CITY OF ALBUQUERQUE

Re: La Mirada Mixed-Use Development Traffic Impact Study
Engineer's Stamp dated August 27, 2021 (G19D004)
Received 8/27/2021
CABQ Planning Transportation comments

The subject Traffic Impact Study for the La Mirada Mixed-Use Development dated August 27, 2021 has been reviewed by the City's Transportation Development Section. The following should be addressed in the next submittal.

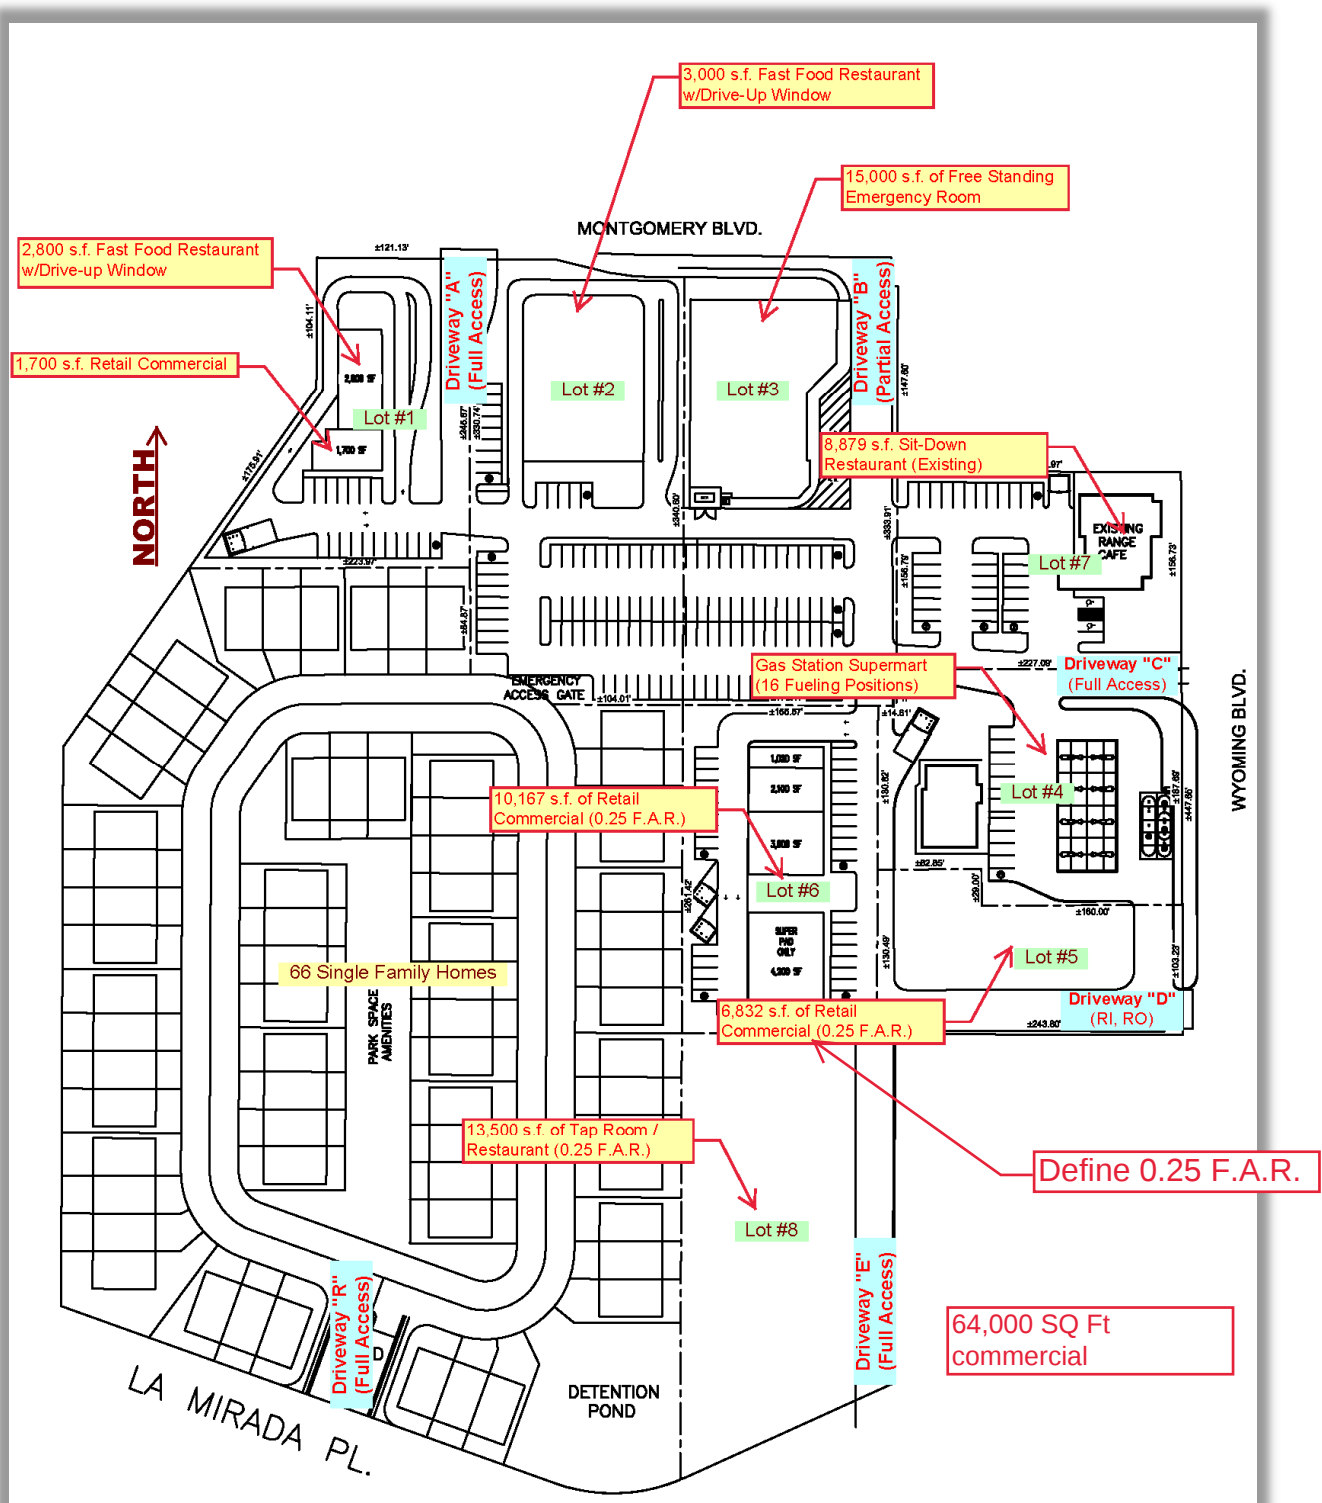
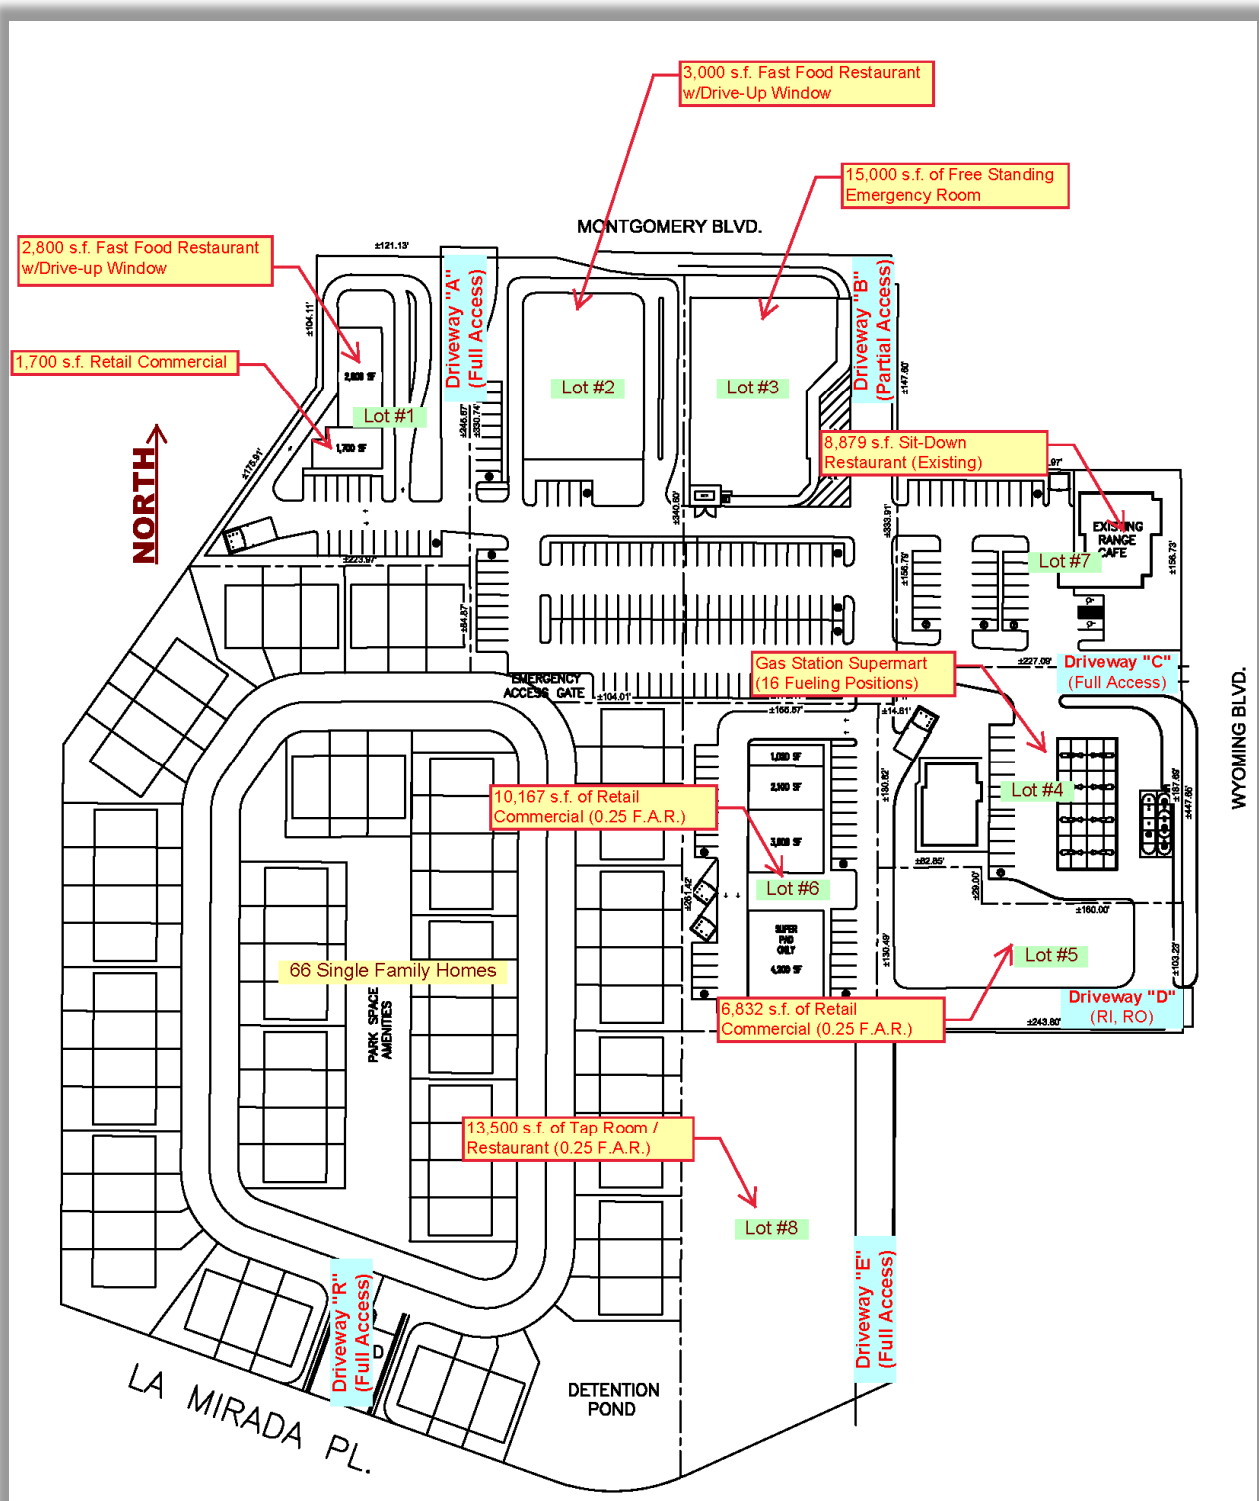
1. Driveway A has poor LOS in all conditions existing and proposed. The failing movements are the northbound combination through/left-turn LOS F, southbound right/left/through movements LOS F and the westbound left LOS F. The opposing traffic volume on Norma Dr. (southbound) is very low but results in a LOS of F. Recommendation is prohibiting the southbound left turn and through movement from Norma Dr and the northbound left turn from driveway A and the westbound left turn from Montgomery into the development. The median opening on Montgomery across from driveway A should be removed.
2. Show the access for Taco Cabana on the site plans. At driveway B relocate the access for Taco Cabana at least 75 feet away from Montgomery Blvd.
3. Define the acronym F.A.R in the conceptual site plan (0.25 F.A.R.)

- Driveway A
 - Eastbound Montgomery at Driveway A, Montgomery no turn lane in existing condition.
 - Northbound Driveway A, not required if right-in/right-out access
- Driveway B
 - Eastbound Montgomery at Driveway B; the existing right turn lane is shorter than recommended in the DPM. Combining the transition and deceleration length is allowed and results in approximately 240 feet which can be permitted.
 - Northbound Driveway B, not required it is right-in/right-out access
- Driveway C
 - Eastbound at driveway C on Wyoming, can be done with lane striping.
 - Southbound Wyoming at driveway C

- Northbound Wyoming at driveway C. The existing length is acceptable when combining the transition and deceleration lengths.
- Montgomery/ Wyoming intersection
 - Montgomery/ Wyoming intersection all right turn movements warrant turn lanes. The development contributes traffic to the eastbound right-turn movement at Wyoming. The other right turn movement have little or no traffic due to the development. A eastbound right turn lane should be added at the Montgomery/Wyoming intersection.
- Wyoming/ La Mirada
 - Wyoming/ La Mirada, eastbound re-stripe with a right-turn lane, thru/left lane

- Northbound Wyoming
 - Northbound Wyoming at La Mirada existing shorter than recommended. Provide expected queue length to assess the existing condition acceptability
- Driveway A
 - Driveway A Northbound left turn, not needed if changed to a right-in/right-out access.
- Montgomery/ Wyoming intersection
 - All left turns have dual left lanes, no change required.

Provide a revised site plan with the driveway and turn lane additions.
